SSD 8593- Ingleburn Resource Recovery Facility 16 Kerr Road Ingleburn NSW 2565 Addendum to Revised Response to Submissions dated October 2020 **Release Date: January 2021**

This Addendum addresses the matters raised in the December 2020 submissions.

1 - Department of Planning, Industry and Environment submission dated 11 December 2020

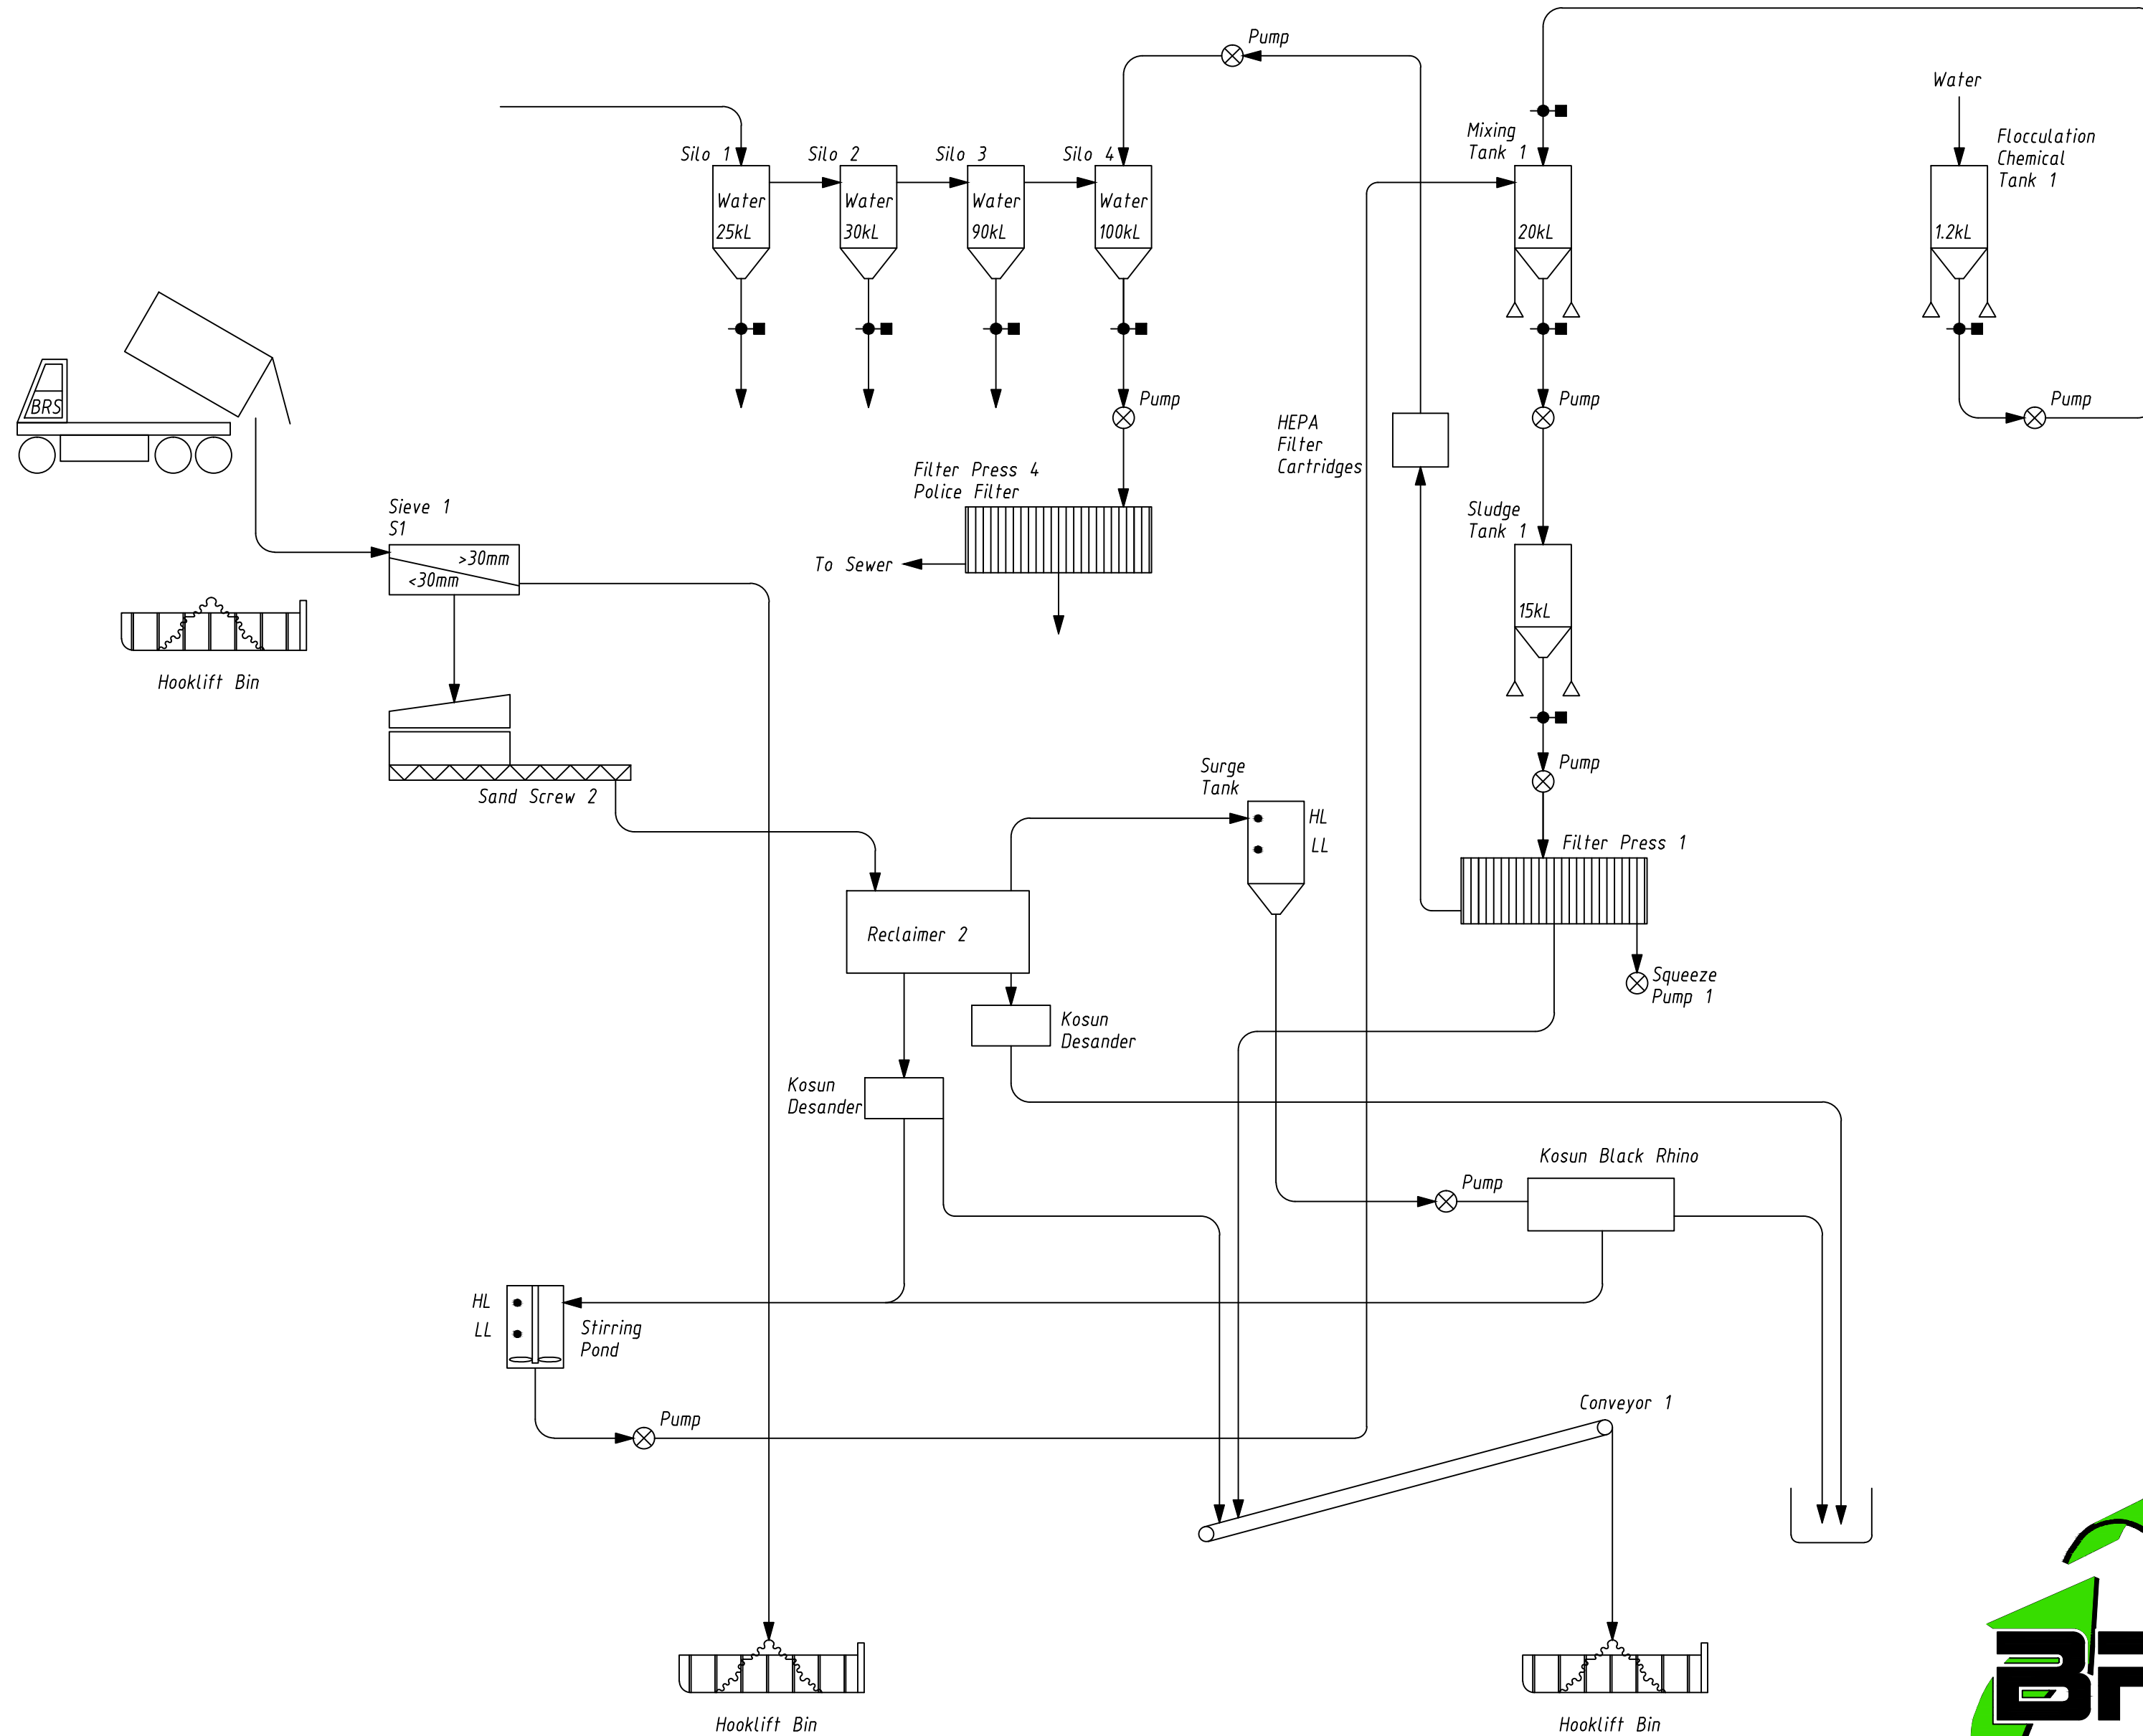
- Please confirm the type of asbestos containing waste to be received on-site. Is it Liquid Containing Asbestos or Asbestos Containing Liquid?
 It is Asbestos Containing Liquid (ACL). This is used to avoid confusion with Asbestos Containing Material (ACM) which implies reference to solids.
- Please describe the processing and treatment methods for the confirmed asbestos waste.
 Details of the processing and treatment of asbestos Containing Liquid (ACL) was included in Appendix D of the BRS October 2020 RTS. Below is a refined proposed methodology to receive and treat the ACL.

If the waste has been tested off-site (preferably at the source) prior to delivery, the methodology outlined below will be followed. However, if the waste was not tested offsite (at the source), it would be stored at the BRS facility within a sealed bin hook lift in the asbestos room in preparation for processing after testing. If the testing confirms that it is Asbestos Containing Liquid (ACL), the methodology outlined below will be followed with a slight modification that in this case the waste will be pumped out from the bin into the pit using a dedicated pump and a flexible hose with suitable connections to prevent spills and leaks.

- 1. As you are aware, Asbestos Containing Liquid (ACL) is transferred to the BRS site in tankers like any other liquid waste.
- 2. The door at the ACL treatment room is always closed unless a tanker is entering or leaving.
- 3. When the tanker arrives, the door opens and the tanker enters the ACL treatment room as per the normal procedure and following clearance with all relevant parties within BRS site.
- 4. The operator engages the flexible hose via a dry coupling to the tanker's dry coupling pipe. The other end of the hose is inside the storage and treatment pit.
- 5. The ACL is emptied into the pit.
- 6. The hose is disconnected from the dry coupling.
- 7. The truck is washed down using high pressurized water hose with trigger nozzle.
- 8. The truck leaves the ACL treatment room as per normal procedure.
- 9. The door is closed.

Please refer to SWMS Entry and decontamination documents for additional information as well as descriptive PI & D flow diagram labelled BRSLS-003.
